ADDRESS:
 ✓ 14370 AIKEN RIDE VIEW

DISAPPROVED
Plan Review
 06/19/2020 3:38:50 PM
 dsdespinoza
 EPC Planning & Community
 Development Department

THE WEIMER ADDITION
14370 AIKEN RIDE VIEW
 COMPUTER FILE # 18-1626

SITE PLAN
 VICINITY MAP
 SITE NOTES

PLOT 08/04/20

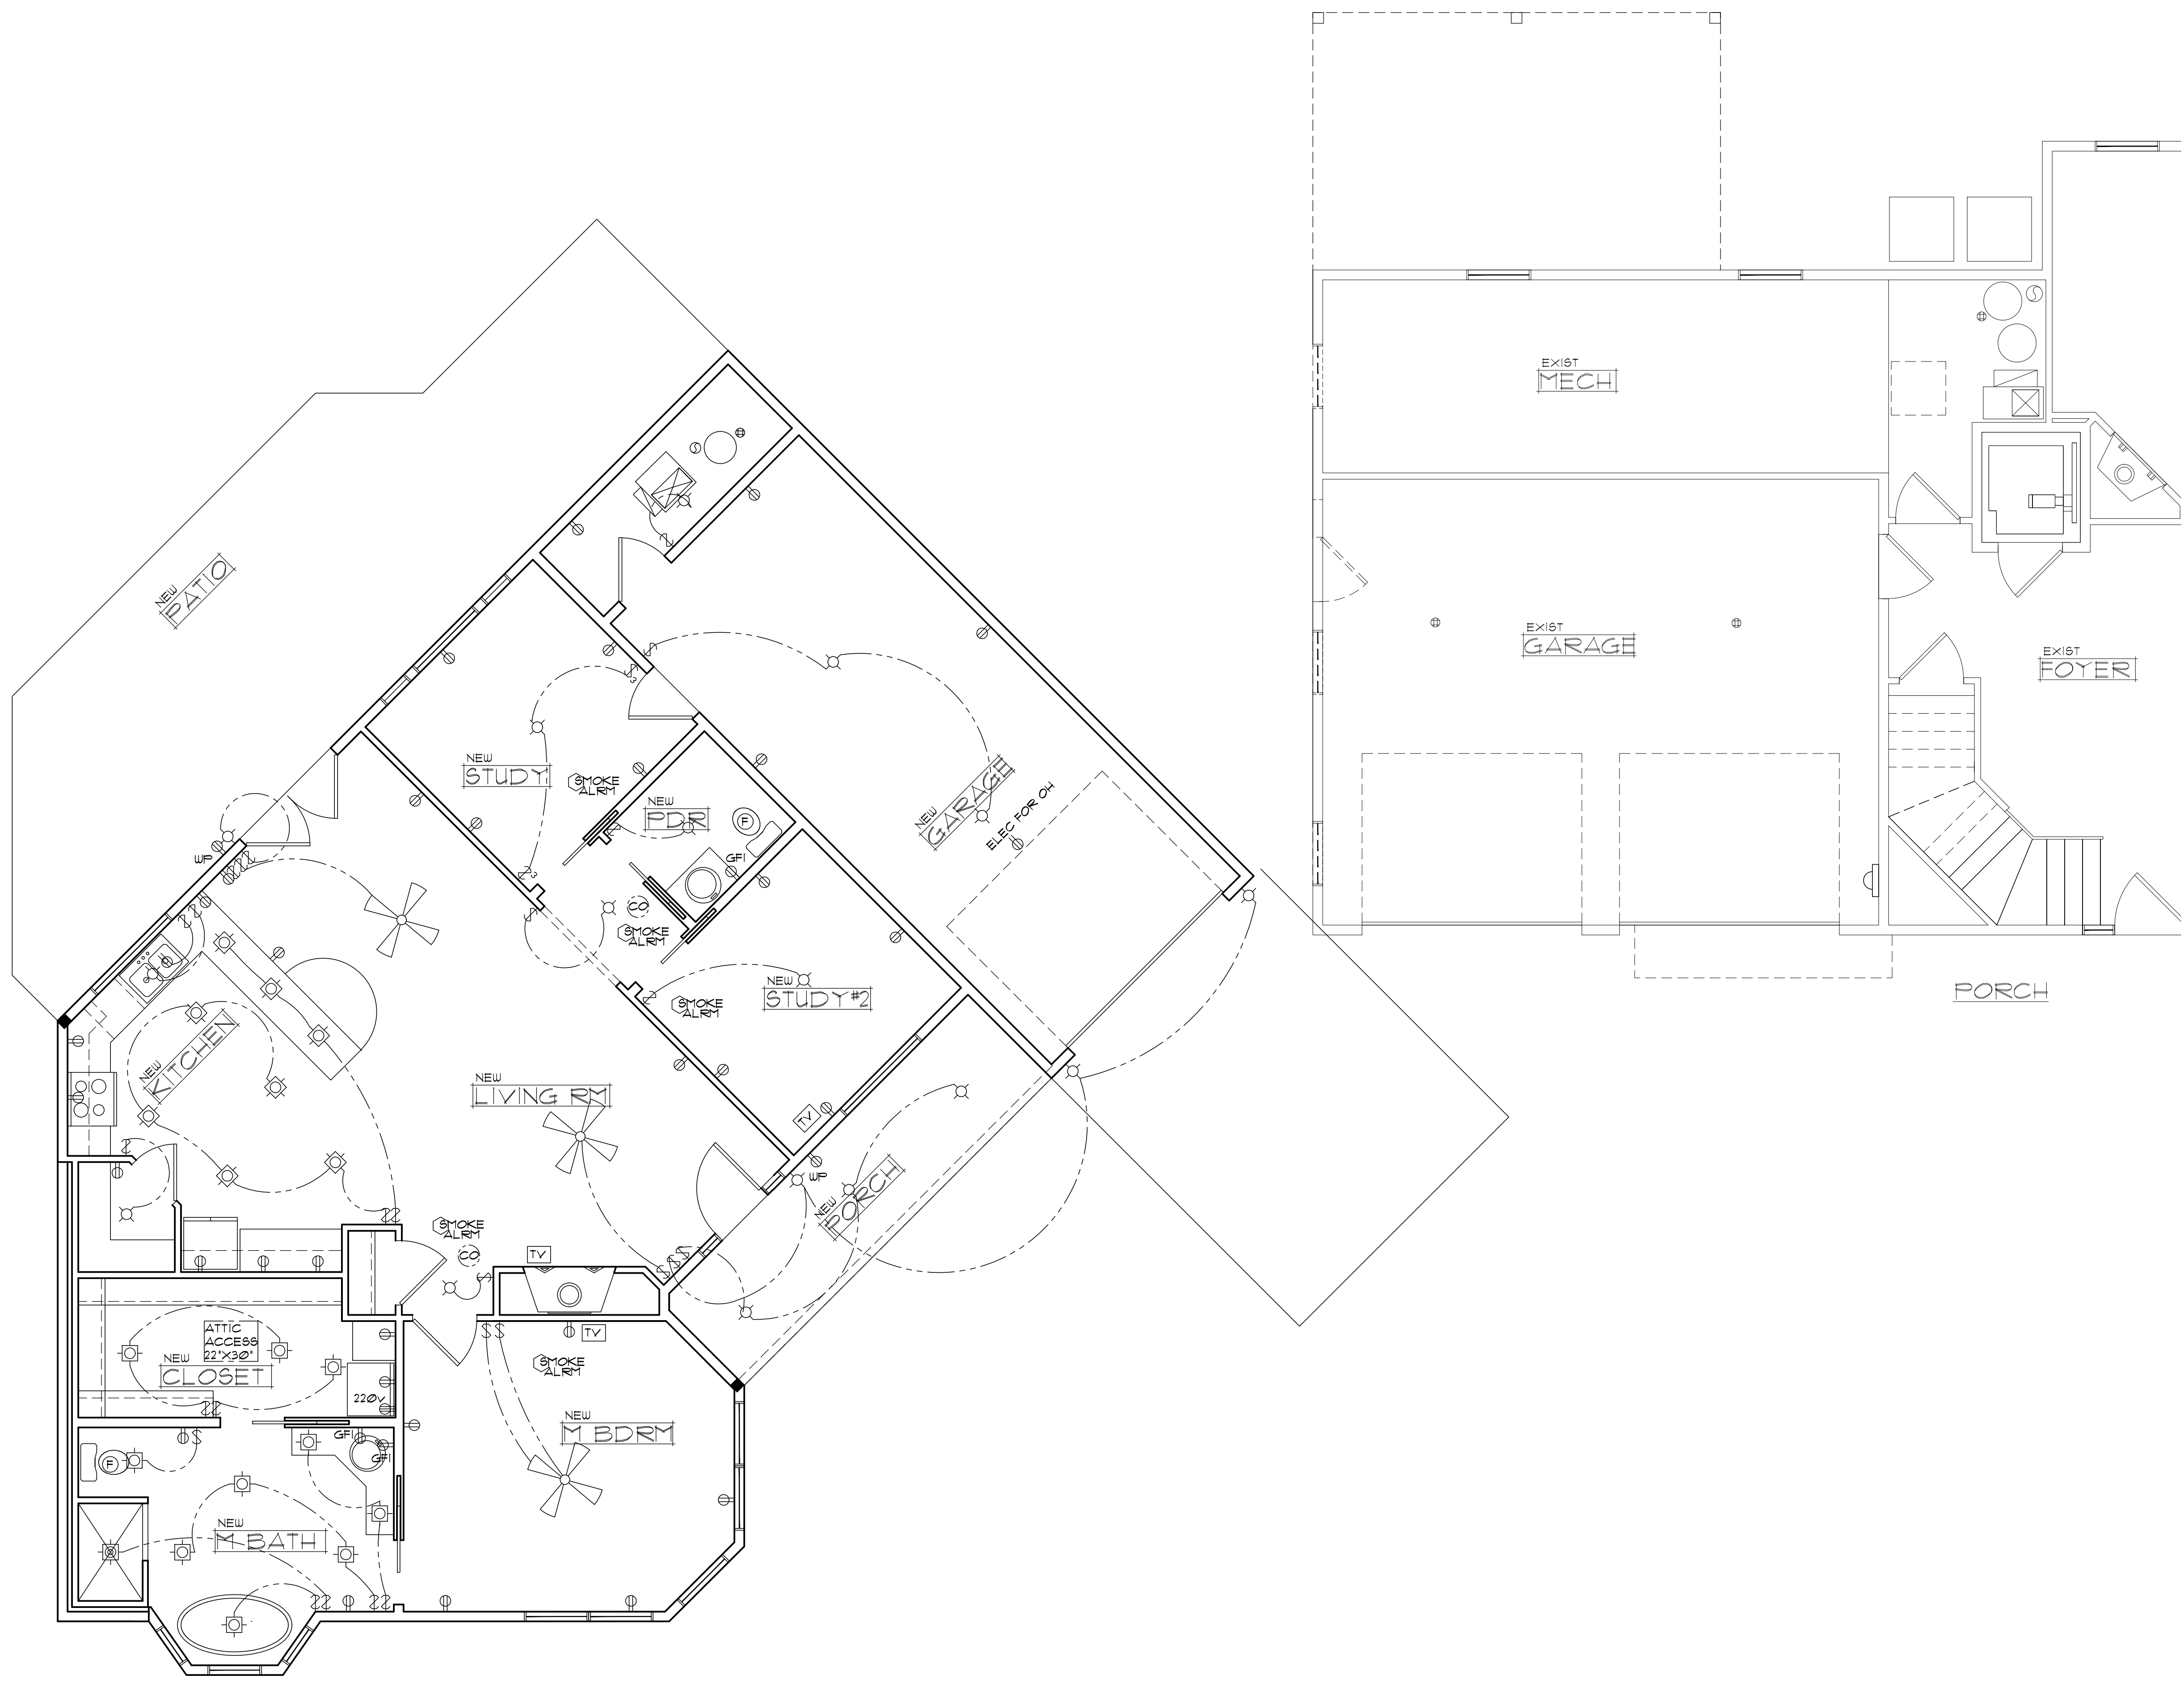
EXCEEDS MAXIMUM ALLOWED HEIGHT OF 30 FT

3. PROPOSED ADDITIONAL ACCESSORY STRUCTURE EXCEEDS MAXIMUM ALLOWED HEIGHT OF 30 FT PER LDC TABLE 5-4: Density and Dimensional Standards for Agricultural, Residential and Special Purpose Districts.
